Gatwick Northern Runway Project DCO (Project Reference: TR020005)

Deadline 6 Submission (26 June 2024)

Joint Surrey Councils – Surrey County Council (Ref. 20044665), Mole Valley Borough Council (Ref: 20044578), Reigate and Banstead Borough Council (Ref. 20044474) and Tandridge District Council (Ref: 20043605)

Figure 1: Location of Contractor Compounds

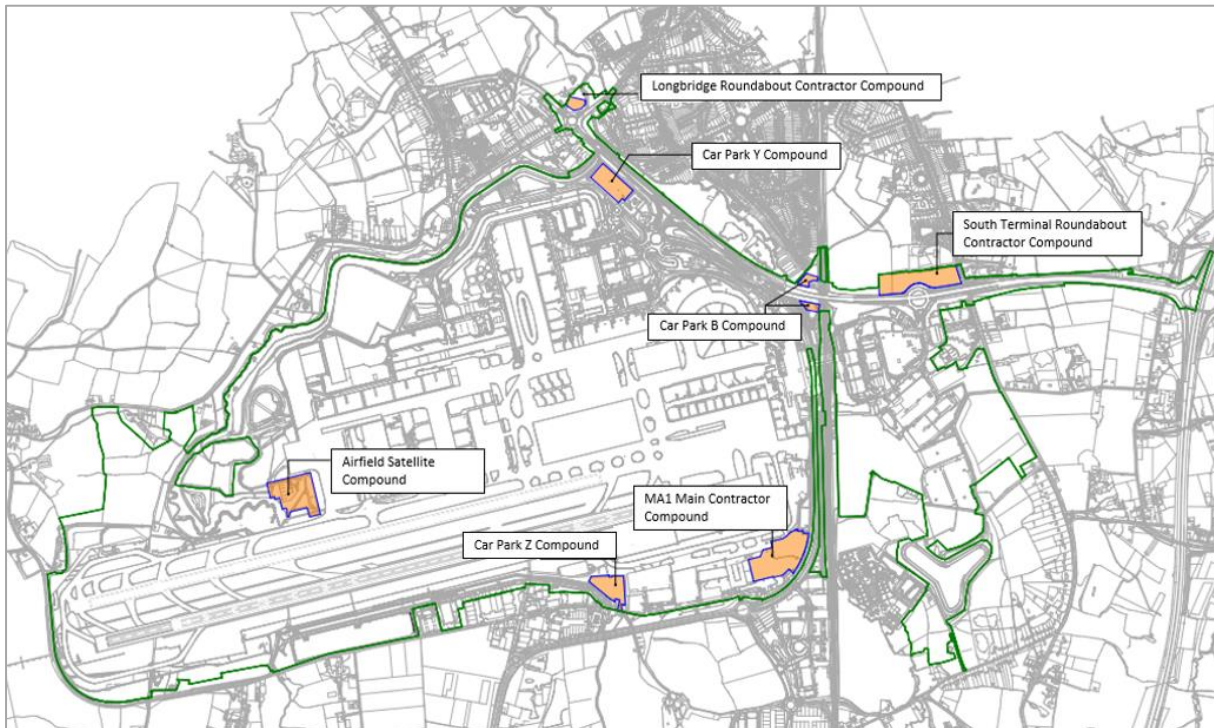
13. Firstly, in relation to the South Terminal Roundabout Contractor Compound. We note that GAL propose that construction workforce privately owned vehicles will still be able to access the site from a secondary entry point at Balcombe Road. SCC are not prepared to accept a construction compound access onto Balcombe Road other than for active travel. All access (construction vehicles, delivery and workforce private vehicles) should be from the purpose-built access off the South Terminal Roundabout, via the SRN. Active local travel can be provided for via a pedestrian/cycle access off Balcombe Road.

14. The second relates to the Longbridge Roundabout Compound. Current access proposals are not satisfactory as they do not prohibit right turning into the site across the A217 immediately northwest of the Longbridge Roundabout. The access should be designed to facilitate left in and left out only, with u-turns being undertaken at the two roundabouts either side of the access.
